From: Jeff Tarling
To: Jean Fraser
Date: 7/23/2015 3:18 PM
Subject: Comments needed please Fwd: Re: 81 Industrial Way

The proposed landscape plan for 81 Industrial Way would benefit from the planting of two additional trees in the parking lot area. One of which would be in the island closest to the exit. Parking lot islands should also have a percentage of 'ground cover' that could consist of native Sweet Fern, daylilies or similar...

**LANDSCAPE PLAN**  
OF:  
**LOT 5 INDUSTRIAL WAY**  
81 INDUSTRIAL WAY  
PORTLAND, ME 04103  
FOR:  
**DEERFIELD 91 INDUSTRIAL, LLC.**  
1 FAN PLACE  
PORTLAND, ME 04101

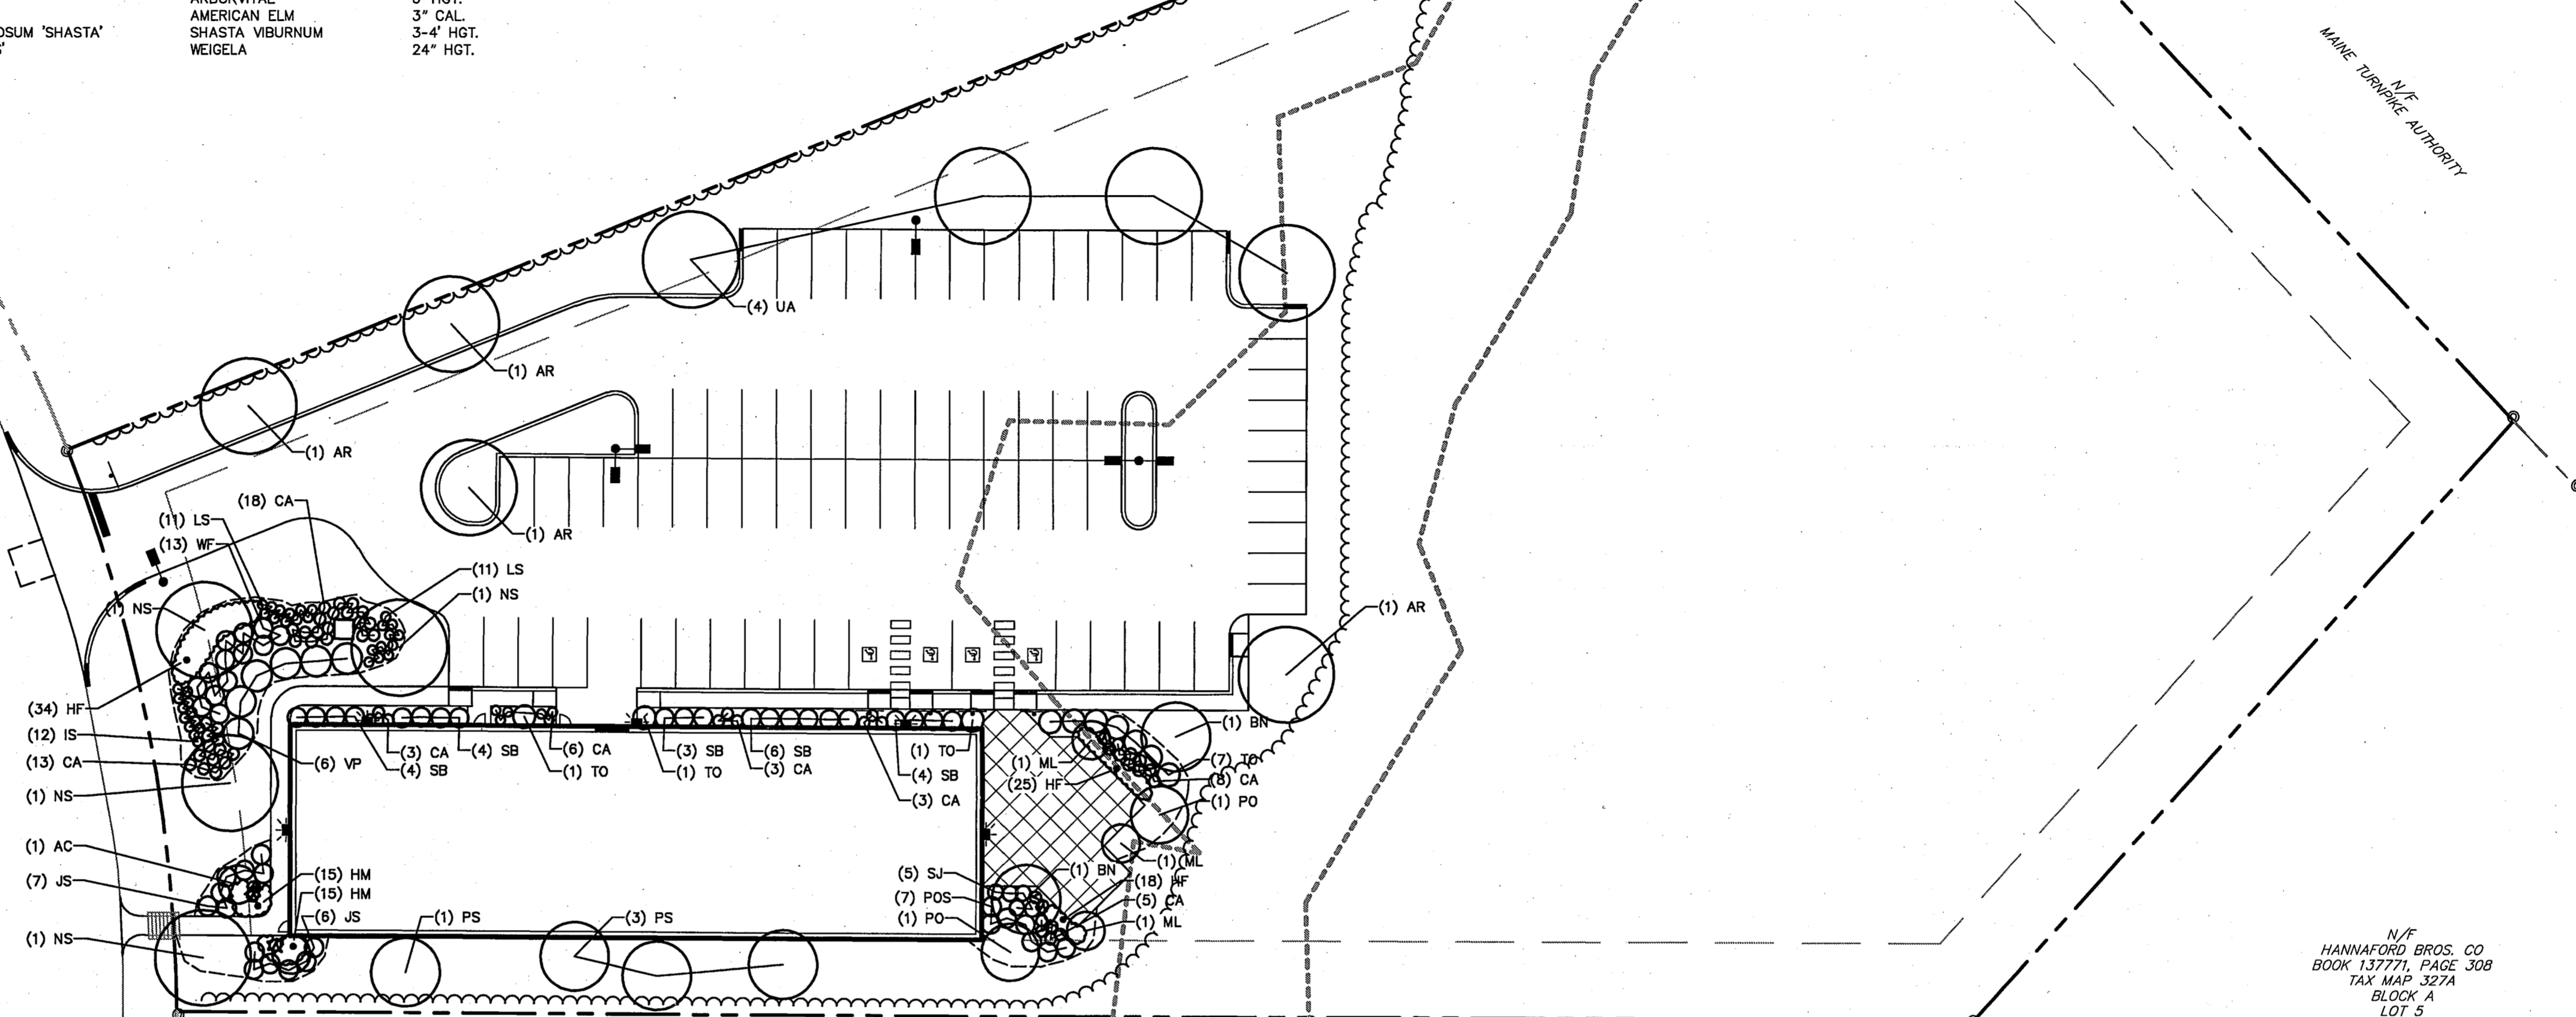
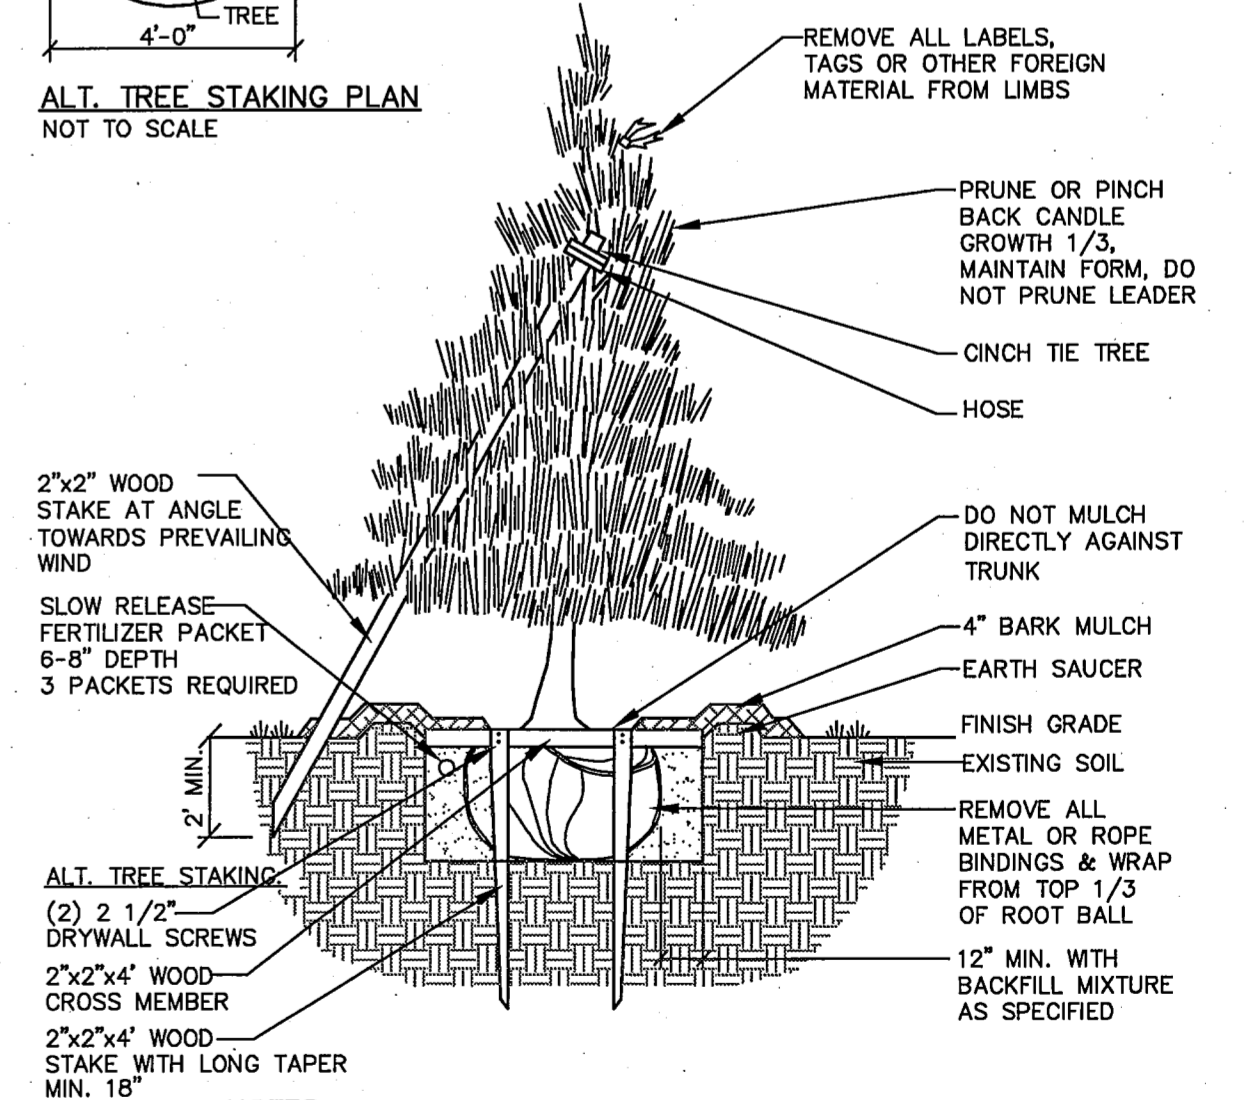
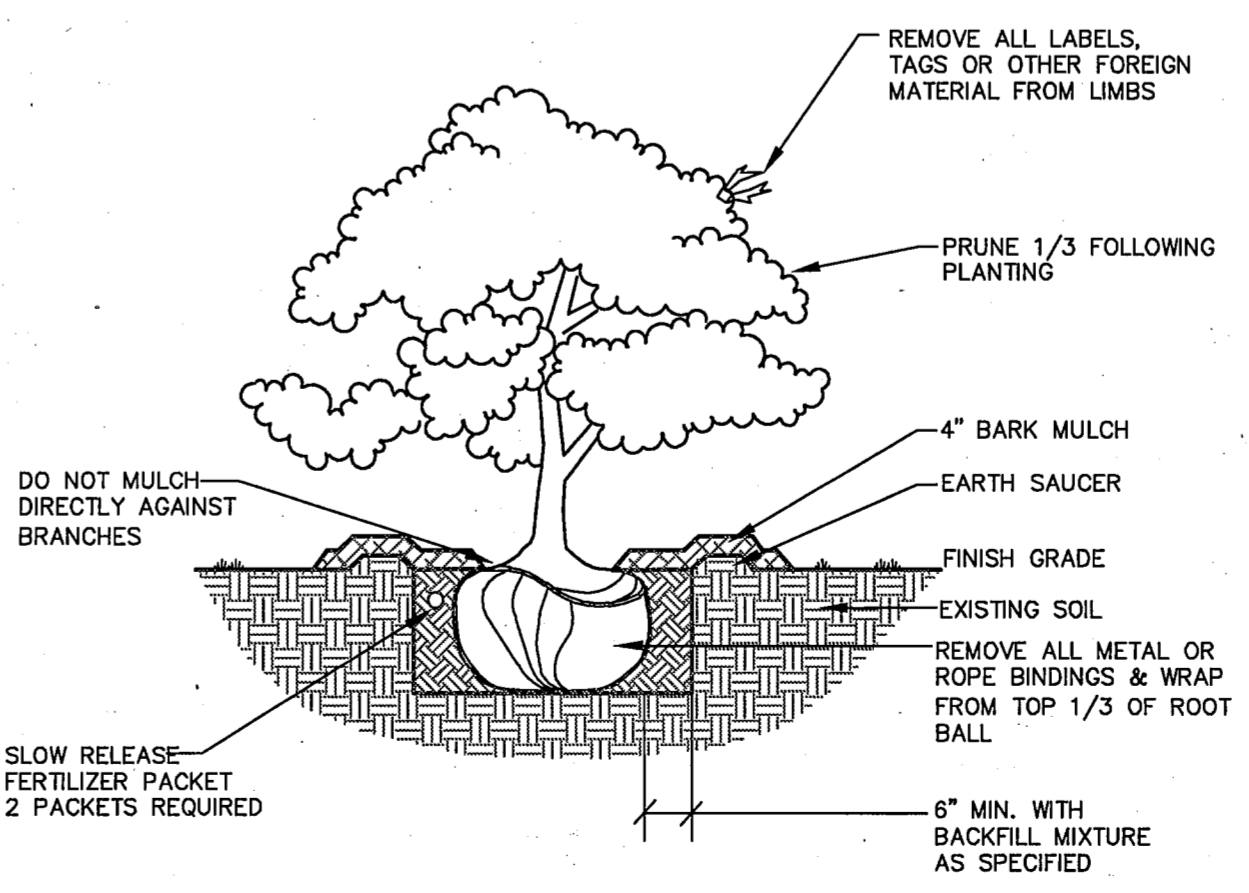
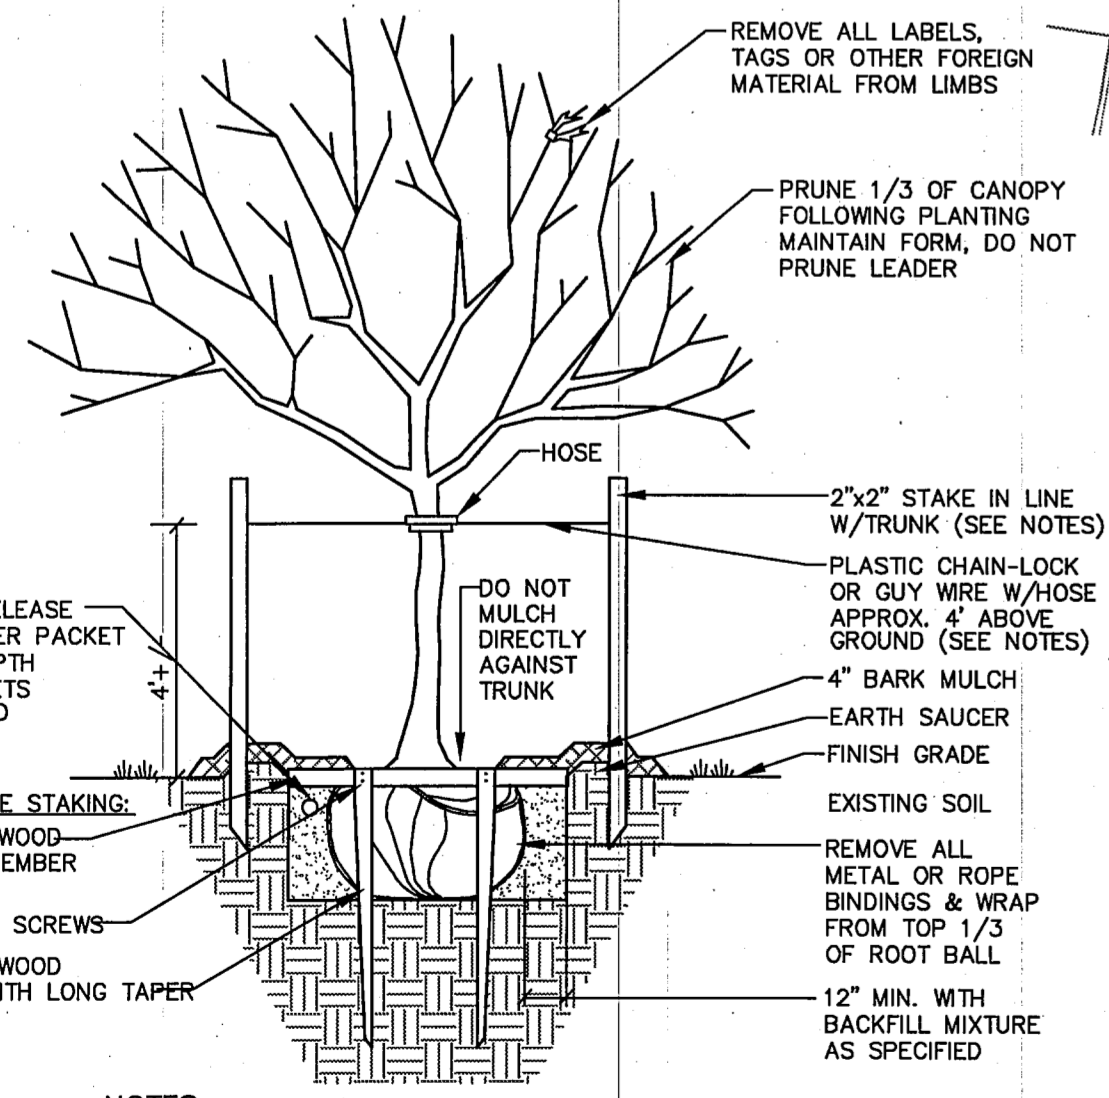
Noted very successful low maintenance planting of Sweet Fern in the parking lot island at Jackson Lab in Bar Harbor recently
Shade trees planted along the edge can be 2" caliper. I am willing to meet with project team if interested to review options.
Thanks,
